**Section 96(1A) Modification Application (MOD 2) to State Significant Development 5169  
Horsley Drive Business Park – Subdivision and Infrastructure Works  
Corner of The Horsley Drive and Cowpasture Road, Wetherill Park**

Further to the correspondence provided, please find below a response to the issues raised from NSW Planning & Environment and Fairfield City Council in relation to MOD 2 to SSD 5169.

ROUNDABOUT LAYOUT & GENERAL ALIGNMENT PLAN
SCALE 1:250

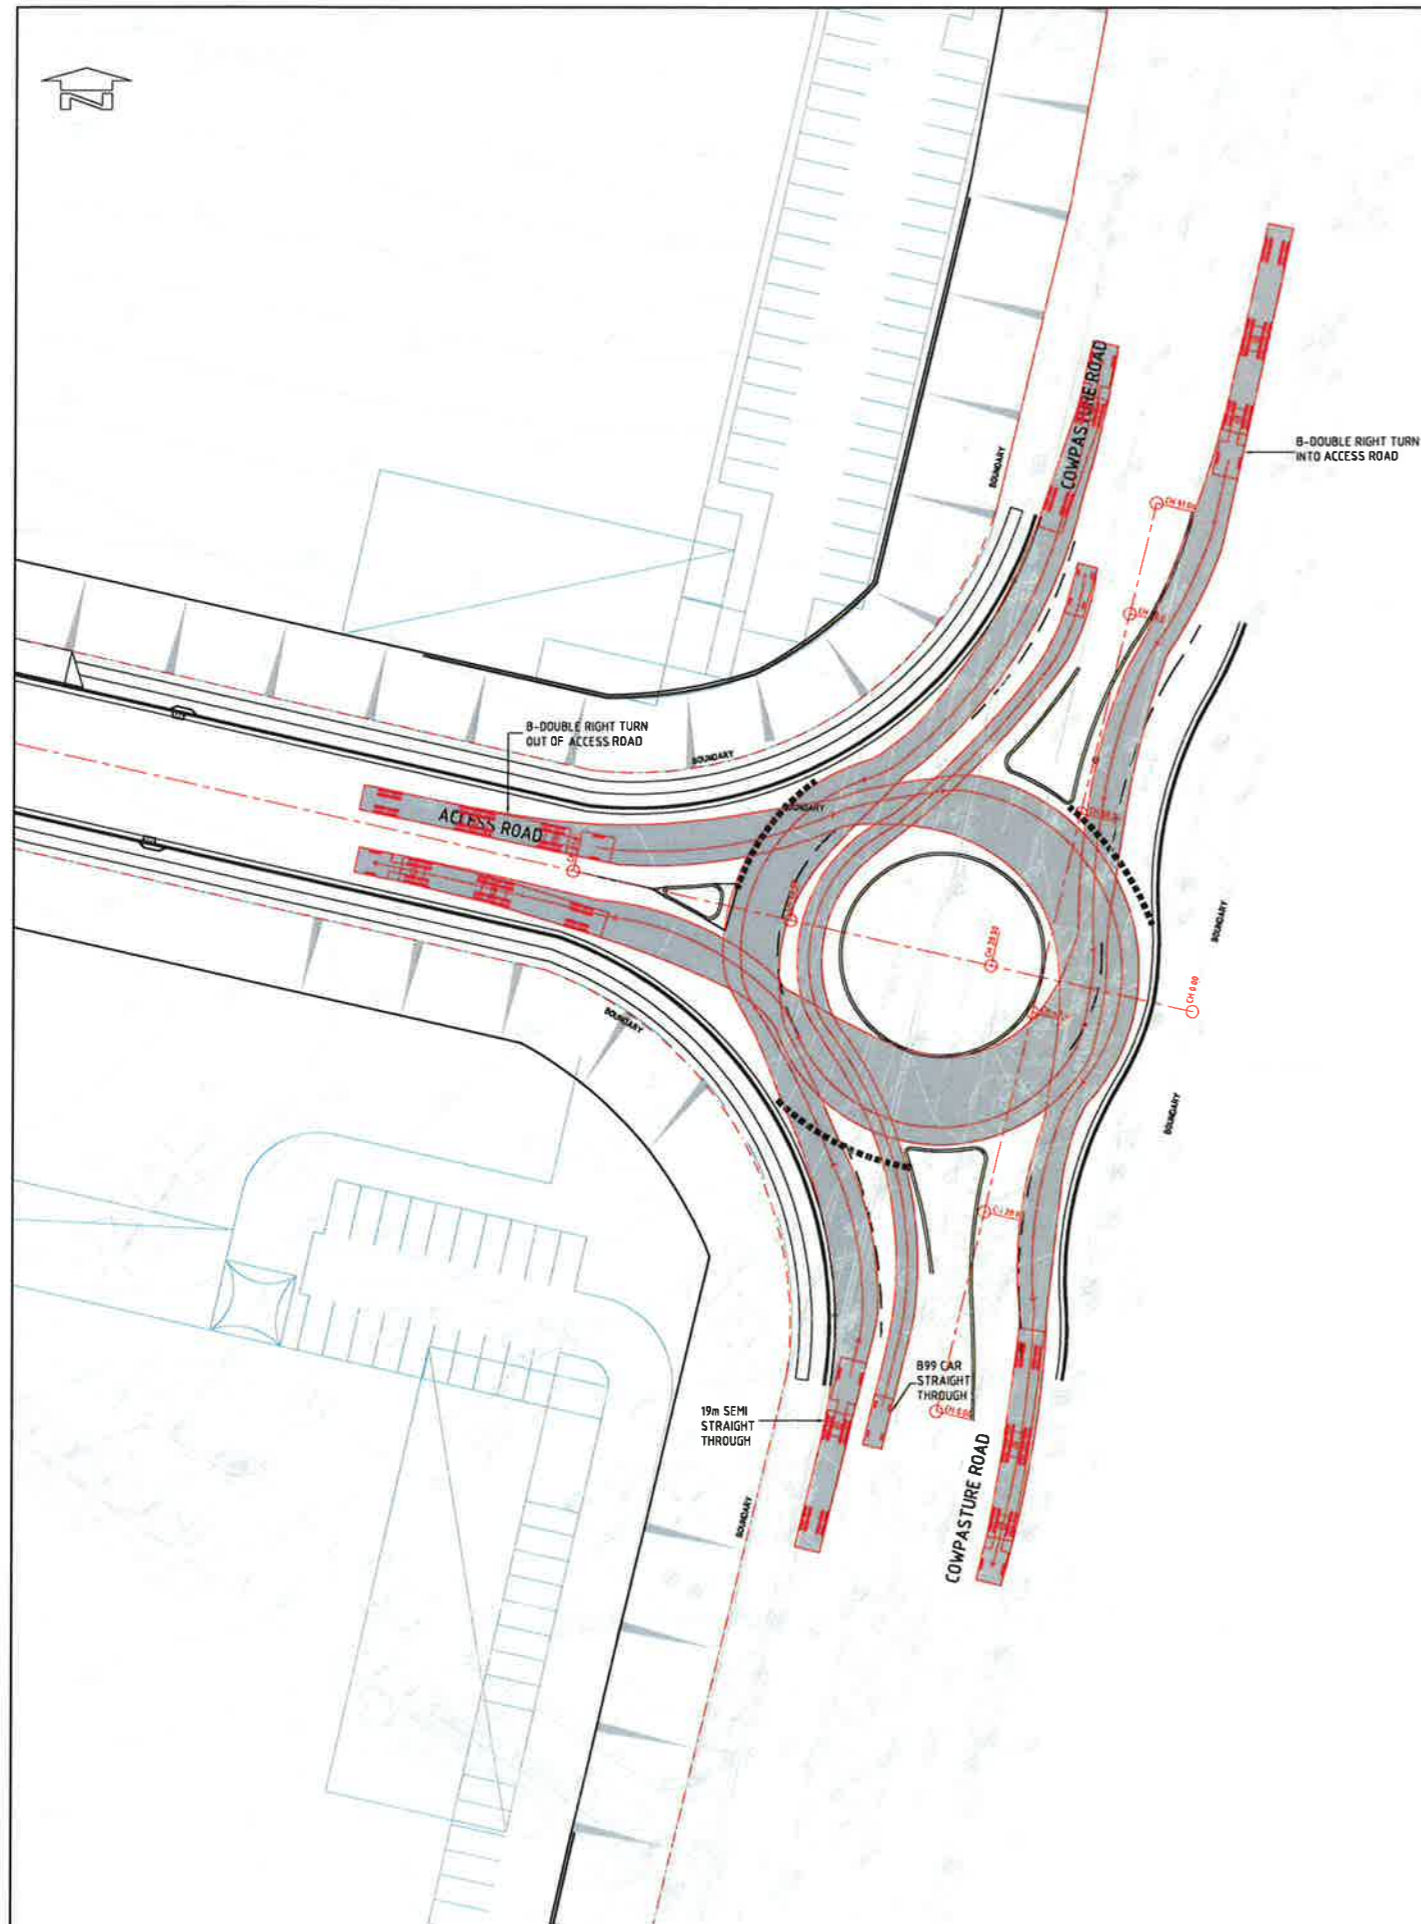
- *Design of the proposed round-about shall comply with Austroads Guide to Road Design Part 4B, Austroads Guide to Road Design Part 4 and Austroads Guide to Traffic Management Part 6. The installation of the round-about requires approval under Section 138 of the Roads Act 1993. A dimensioned plan of the round-about shall be submitted to Council and the plan will require approval from Fairfield Traffic Committee.*

**Comment:** The design of the round-about has previously been dealt with as part of the Civil Design Drawings by Costin Roe Consulting. Refer to Drawing SK01 at Appendix 6 of the main Planning Report prepared.

DRAWING TITLE:
ROUNDBABOUT TURNING PATHS
PLAN
Drawing No: Co114.92.05-SK02
Scale: A

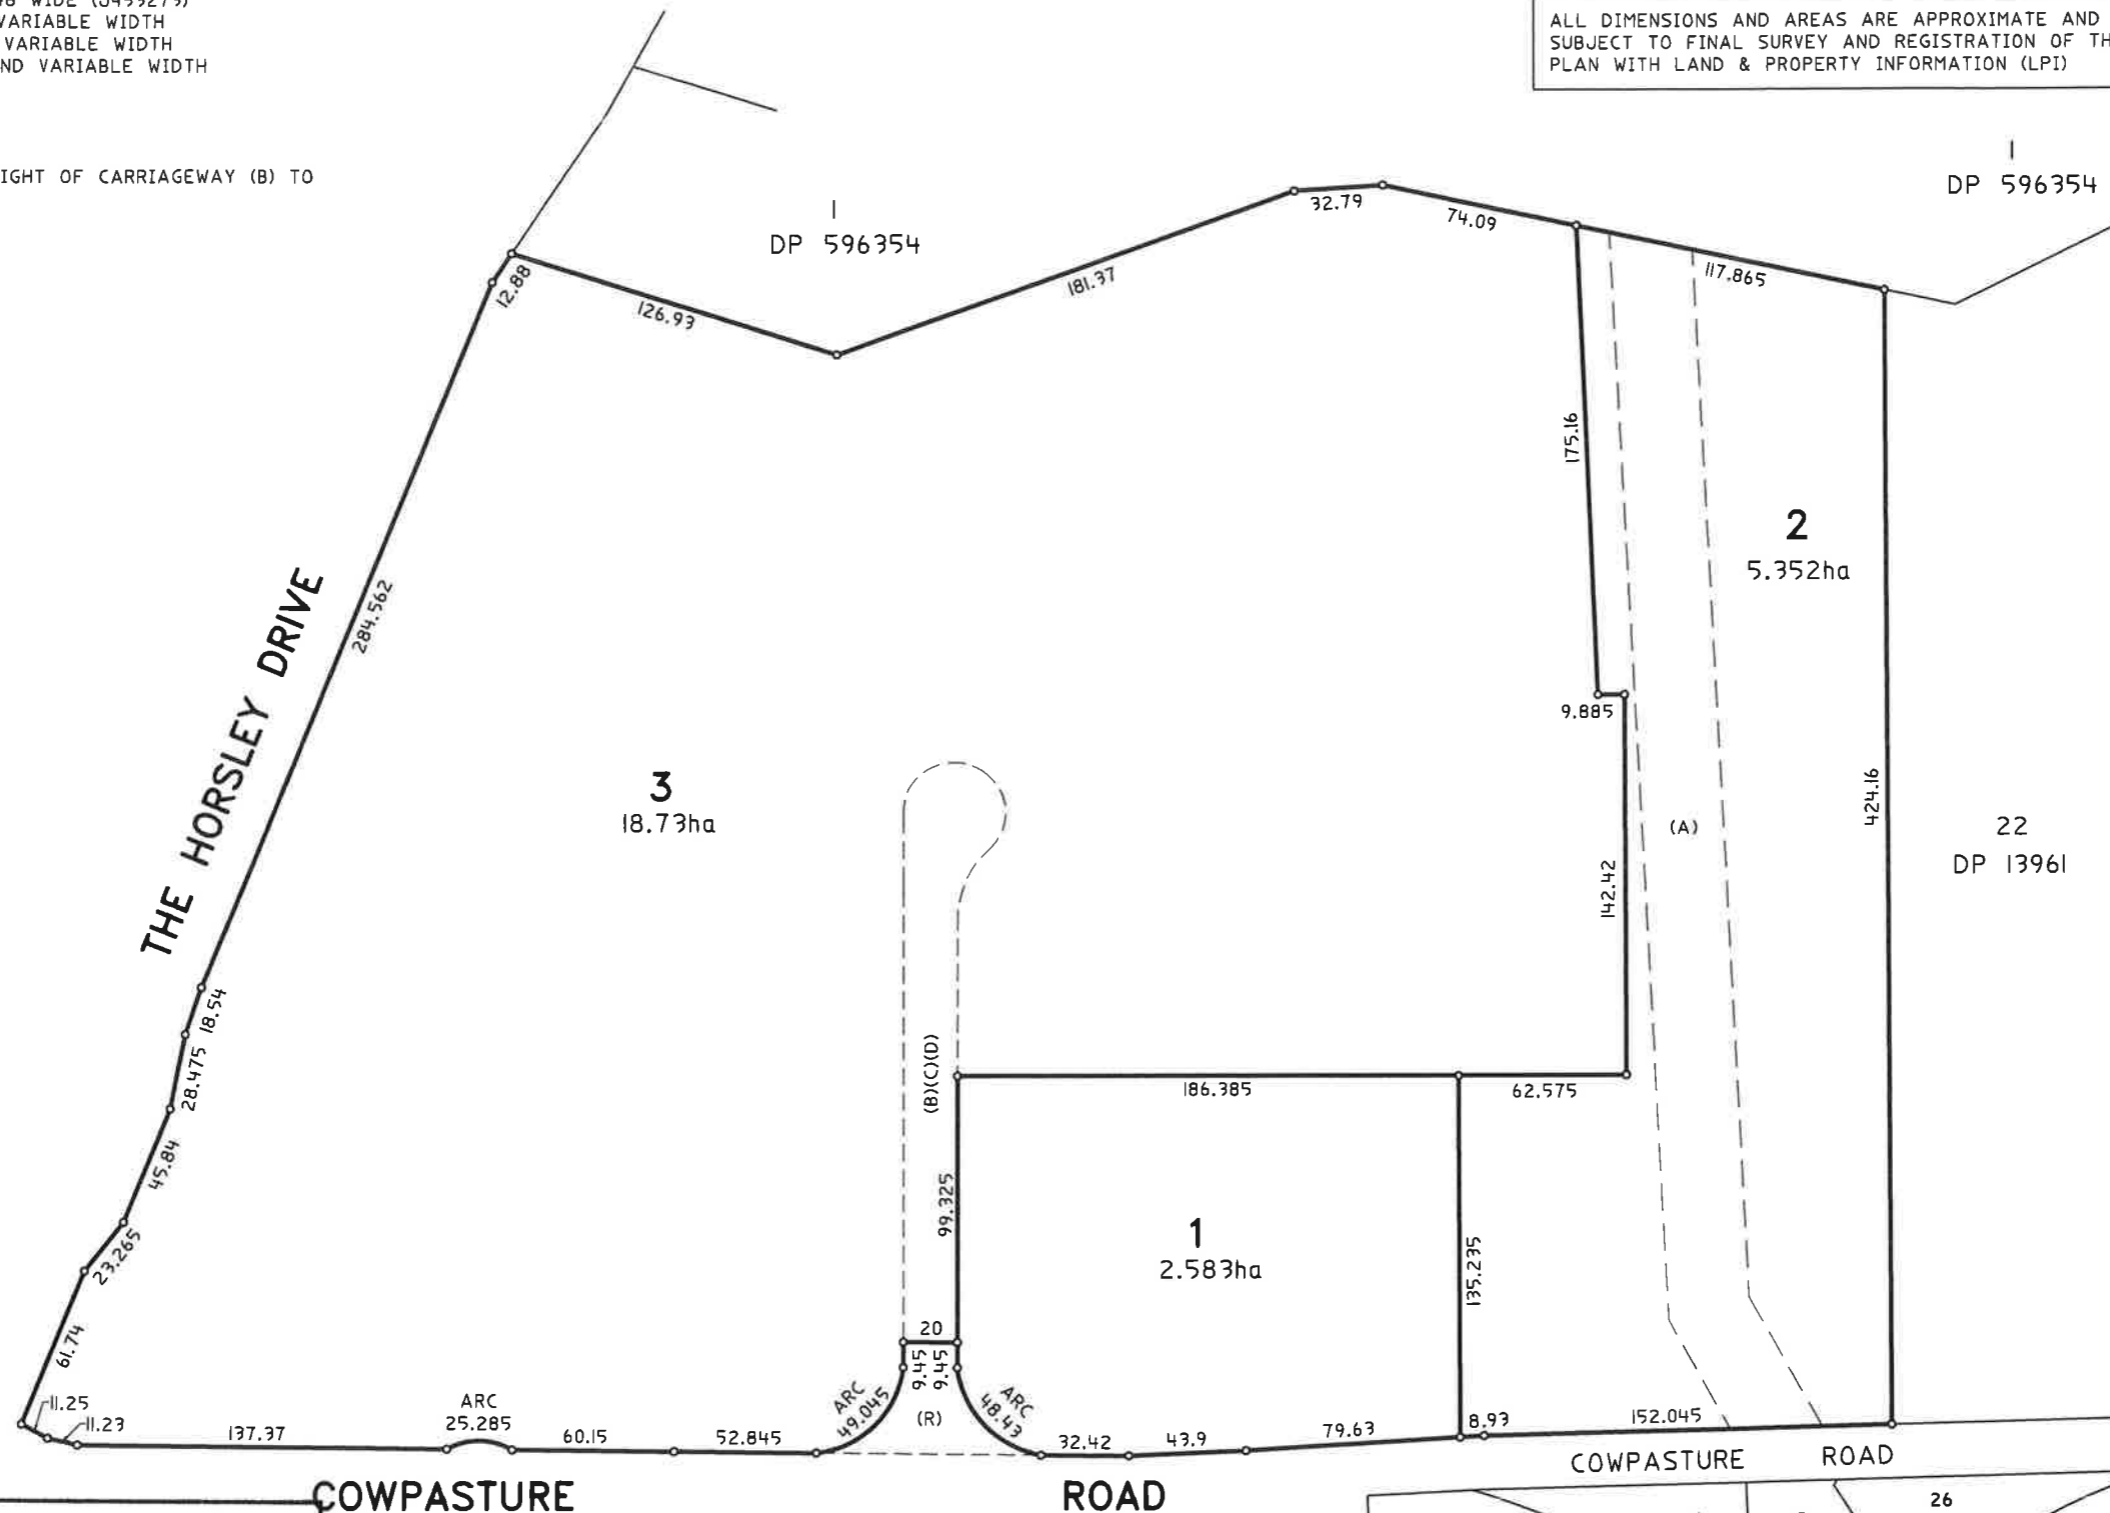
- *Turning path templates for B-Double vehicles shall be used to justify circulation within the proposed round-about and entering/exiting from The Horsley Drive Business Park is satisfactory. Swept Path diagrams shall be submitted to the council for assessment.*

**Comment:** The turning path templates have been previously provided and are included as part of the Civil Drawings. Refer to SK02 at Appendix 6 of the Planning Report.
